**Application Y/40/17/OUT Bonhams
Response to Landscape Appraisal (April 17) PR121167LANDAPP**

I am registering a specific objection to this document, which forms part of the outline proposal for application Y/40,17/OUT

Viewpoint 6: Cycle route and road users

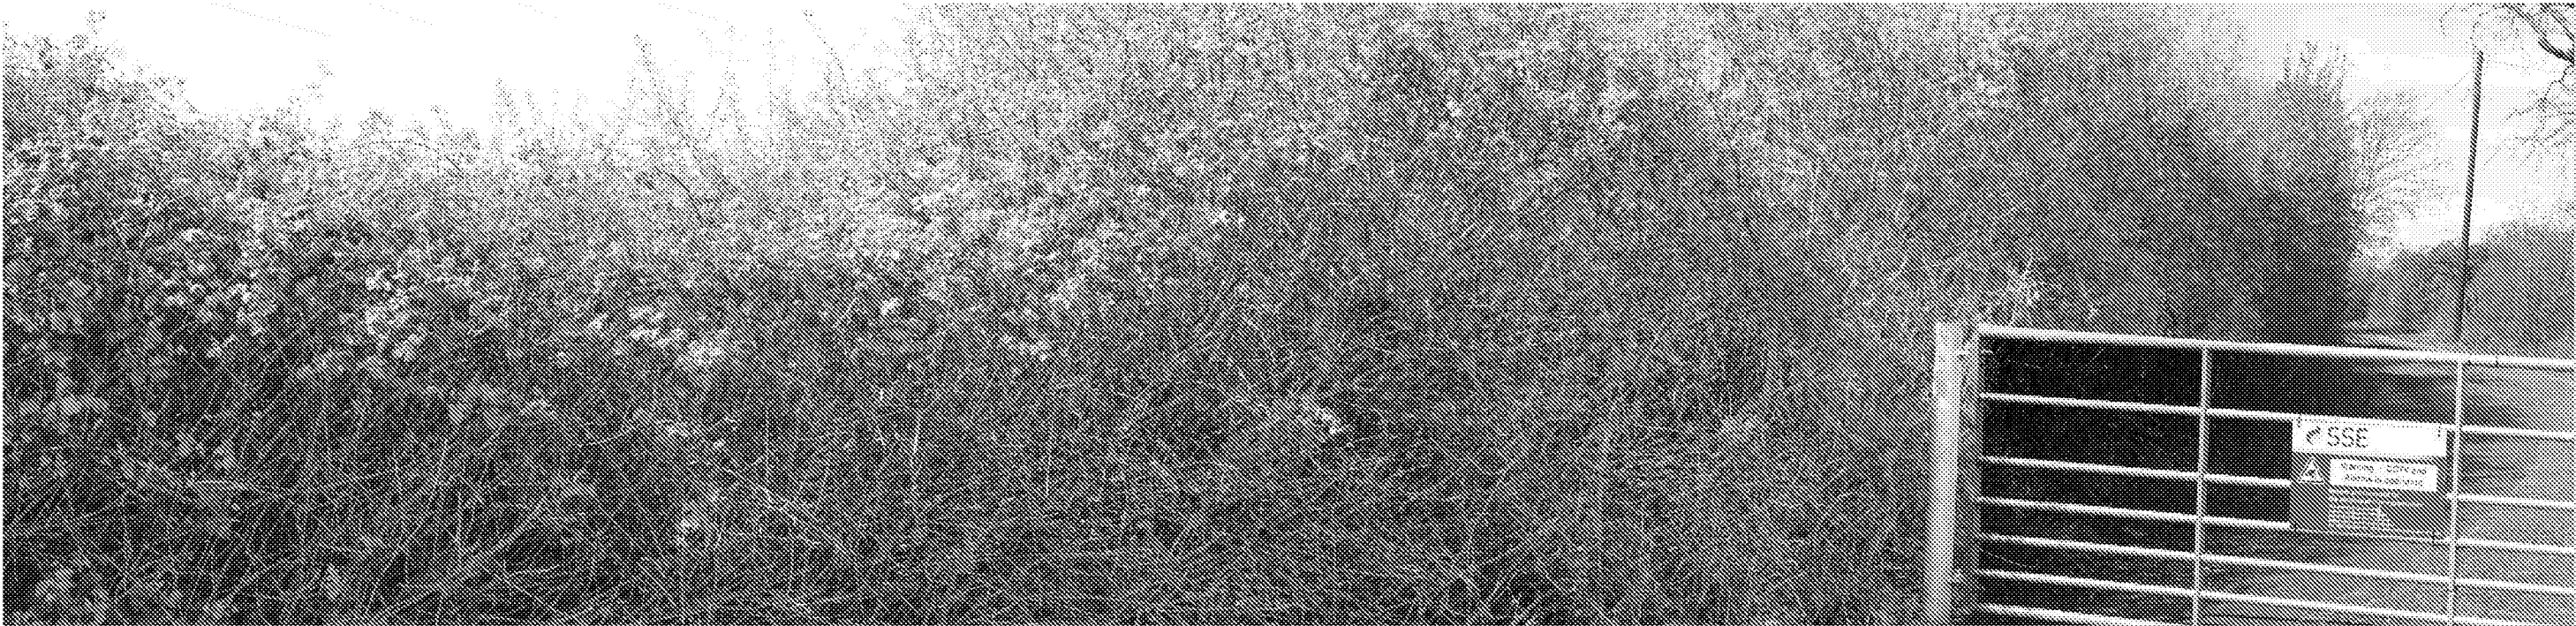
Viewpoints 5, 6 and 7:

- These photographs are taken from sites at such distances from the site, and/or in locations where even the existing buildings of Flansham are not visible. The clearly show that Flansham is a 'hidden hamlet', entirely surrounded by agricultural land and green lanes. The proposed development would change this forever.
